From: Mark Coates
Sent: 19 September 2018 12:06
To: Richard Castro-Parker
Cc: Juan Baeza; Nat King-Smith (MHA); 'Clare Sutton (MHA)'
Subject: RE: New Parking Scheme re: 1-7 Canada Road ref: AB/4/18/PL

Please see the below comments from highways re: the parking re: 1-7 Canada Road ref: AB/4/18/PL. Please could you address the point raised. As there are a number of parking issues that need dealing with, it is considered that it would not be sensible to bring this application to committee on the 3rd October.

Subject: New Parking Scheme re: 1-7 Canada Road ref: AB/4/18/PL

Site Plan 1:200

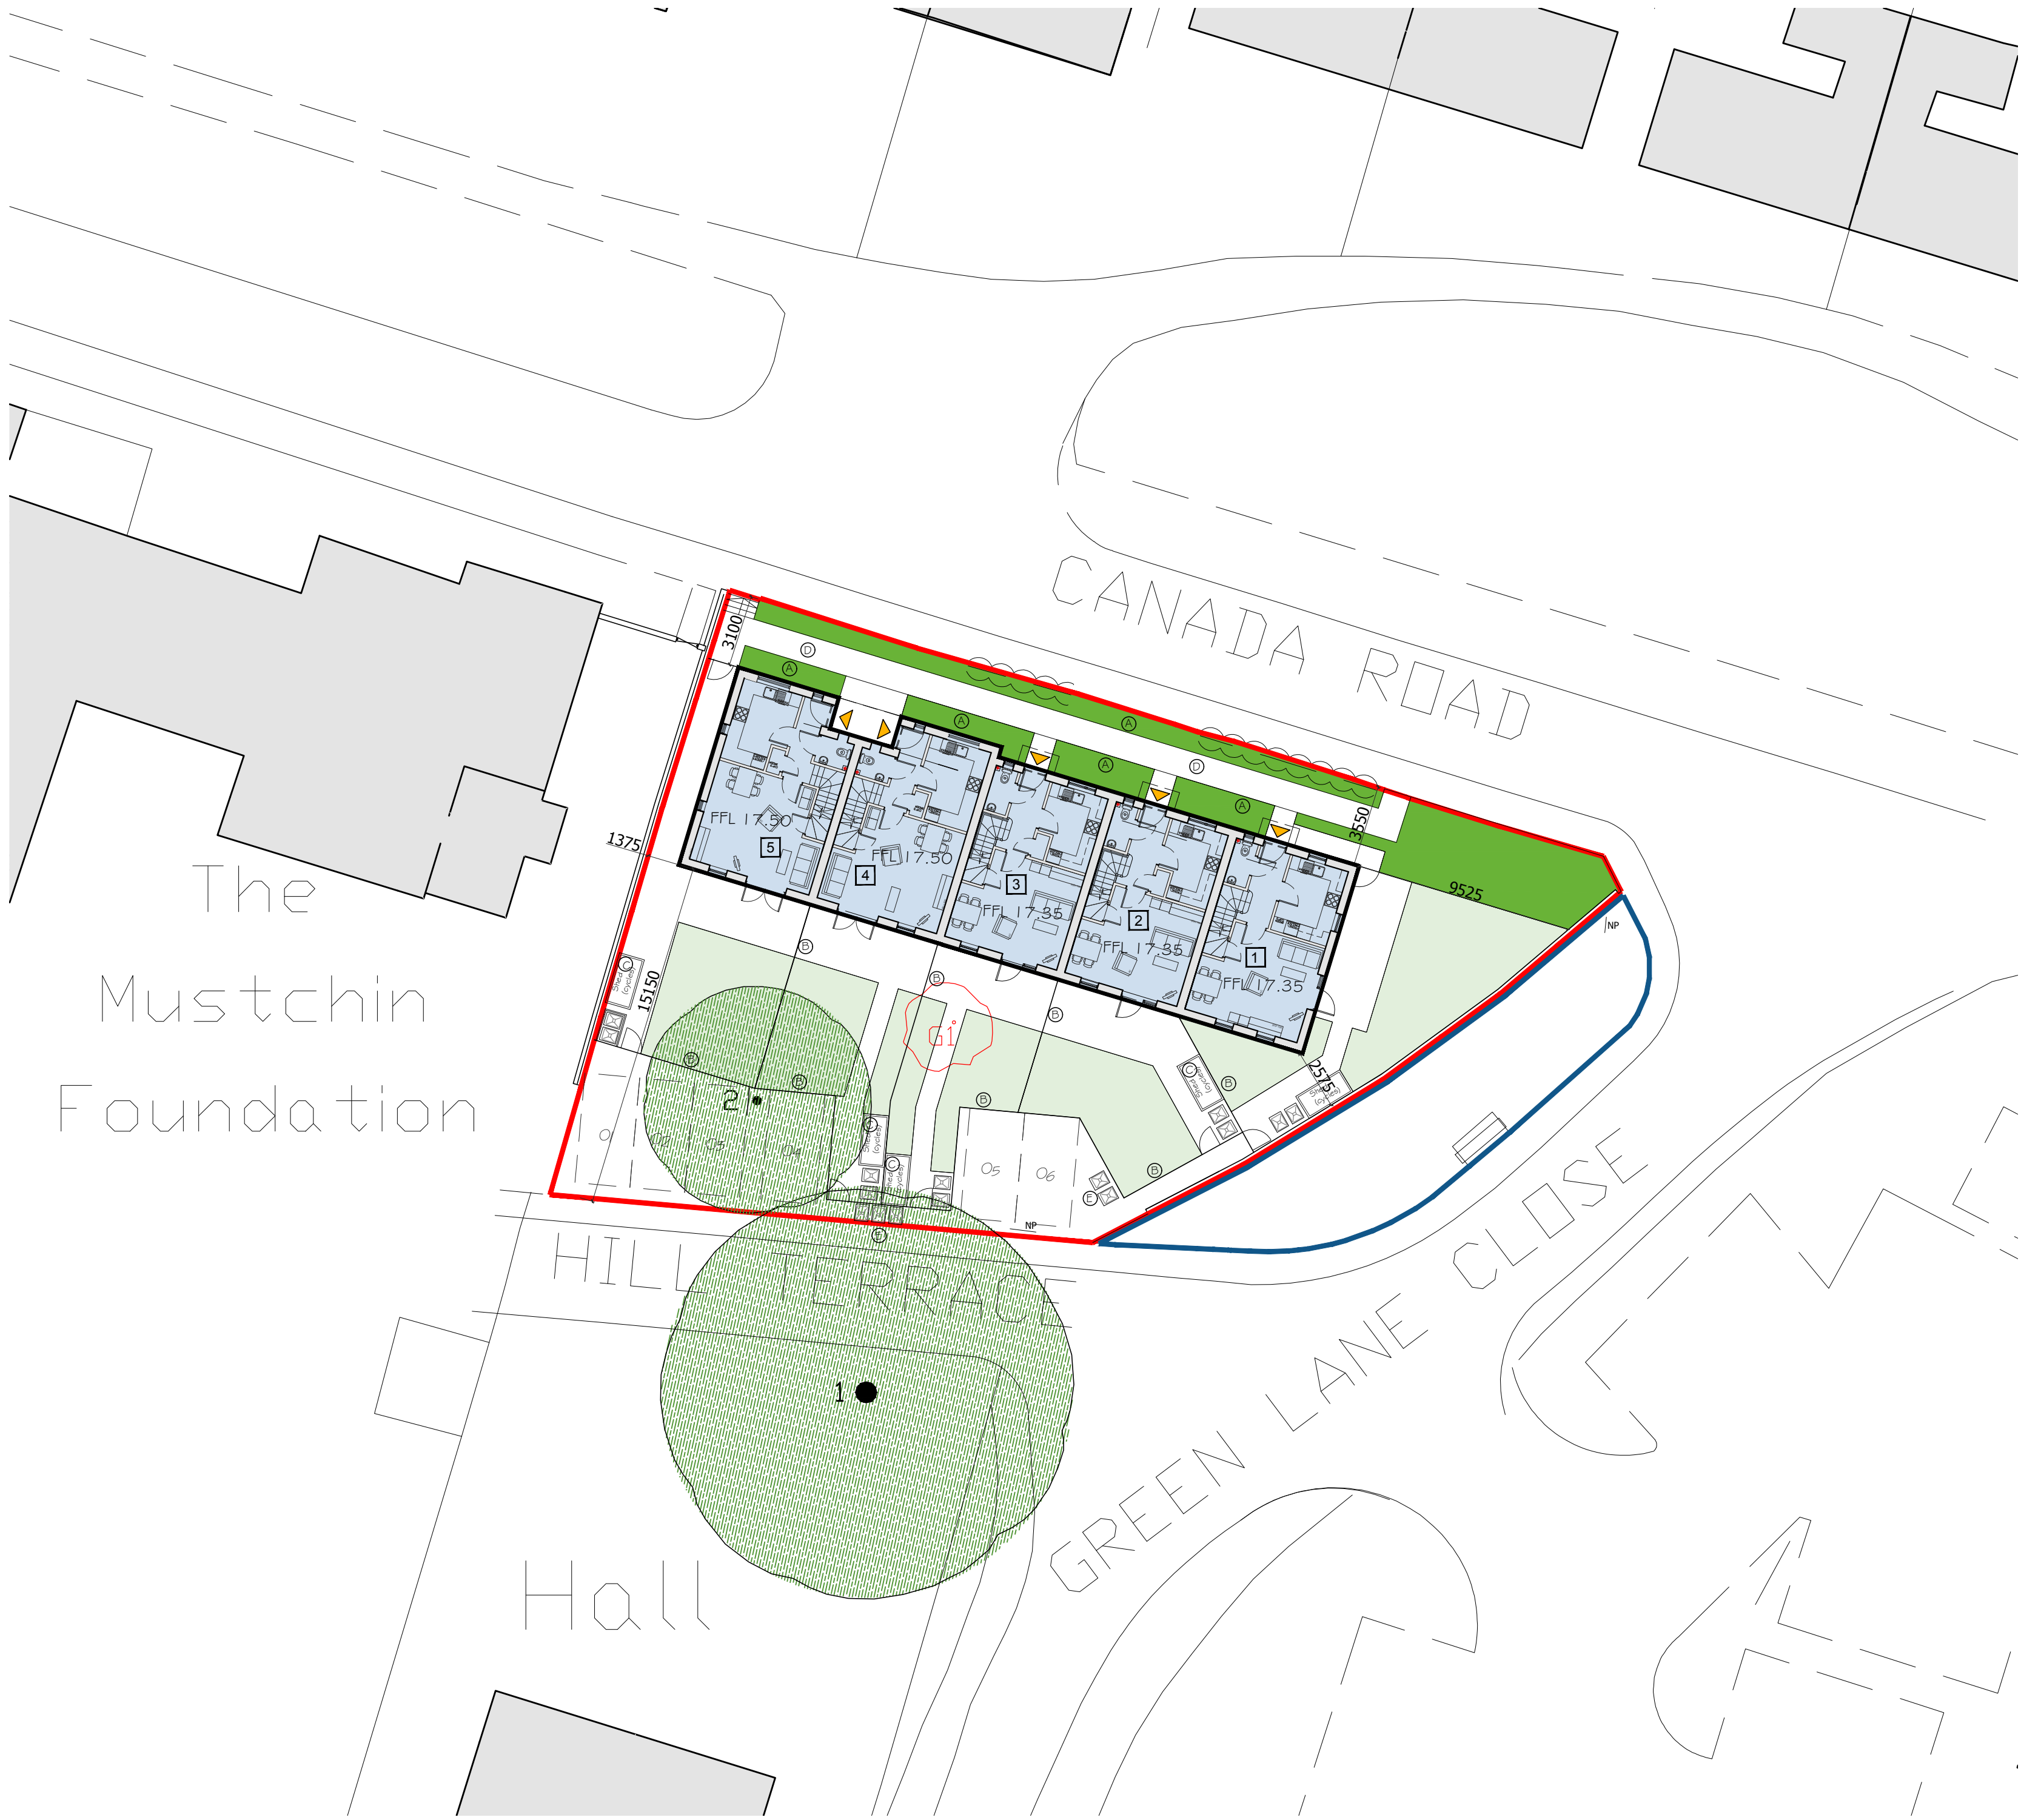
I note the site plan provided annotates areas 'owned' by WSCC. This is not strictly true as the areas indicated as considered 'adopted public highway' and not 'owned' by WSCC.

The layby arrangement will require land consider public highway and thus the spaces created could not be reserved for use specific use by residents of the proposed units. I note a slither at the southern extent of these spaces is not adopted highway.

Is it intended to have the areas of public highway within then layby 'Stopped Up', spaces could then be used specifically for residents of the proposed units, or will its status as public highway remain? If it is to remain as public highway will the slither of land be put up for adoption under a Section 38 Agreement?

Is it intended that the relocated footway will be offered for adoption under a Section 38 agreement? Ideally any newly created footways should be a minimum of 2.0 metres in width, this does not seem to meet this minimum width.

There is a question if the highway works should also be subject to a Stage 1 Road Safety Audit, presumably this has not been done given the change is quite recent. If you can look into the matters above regarding the applicants intentions over the layby and footway status I will consult this end and see if the works should be subject to a Safety Audit.

As the Highways do not require a Road Safety Audit, the only change will be to widen the footpath by 200mm which can be achieved without a problem.

Apart from a drawing showing the revised footpath width and a revised annotation of 'Adopted Public Highway ' is there anything else you require ?

The annotation regarding 'ownership' was in relation to the notice that was required to be served to WSCC highways as this area of land is not owned by Arun District Council.

It is not proposed that the parking is for the sole use of residents of the proposed units. The spaces in the layby are indicated on the drawing as unallocated.

Both the 'slither' of land in the laybys and the footpath will be offered for adoption under a section 38 agreement.

The proposed footpath is 1800mm wide and will replace the current footpath which varies between 1400mm and 1650mm wide. It will connect to the existing footpath in front of the Mustchin Foundation which is approximately 1800mm wide. If necessary we will amend the site plan to increase the footpath to 2m.

If a stage 1 road safety audit is required we will commission one but I would note that currently cars can park on both sides of this narrow road - see attached photo courtesy of google maps and that the addition of the layby, increasing the width, should improve the safety.
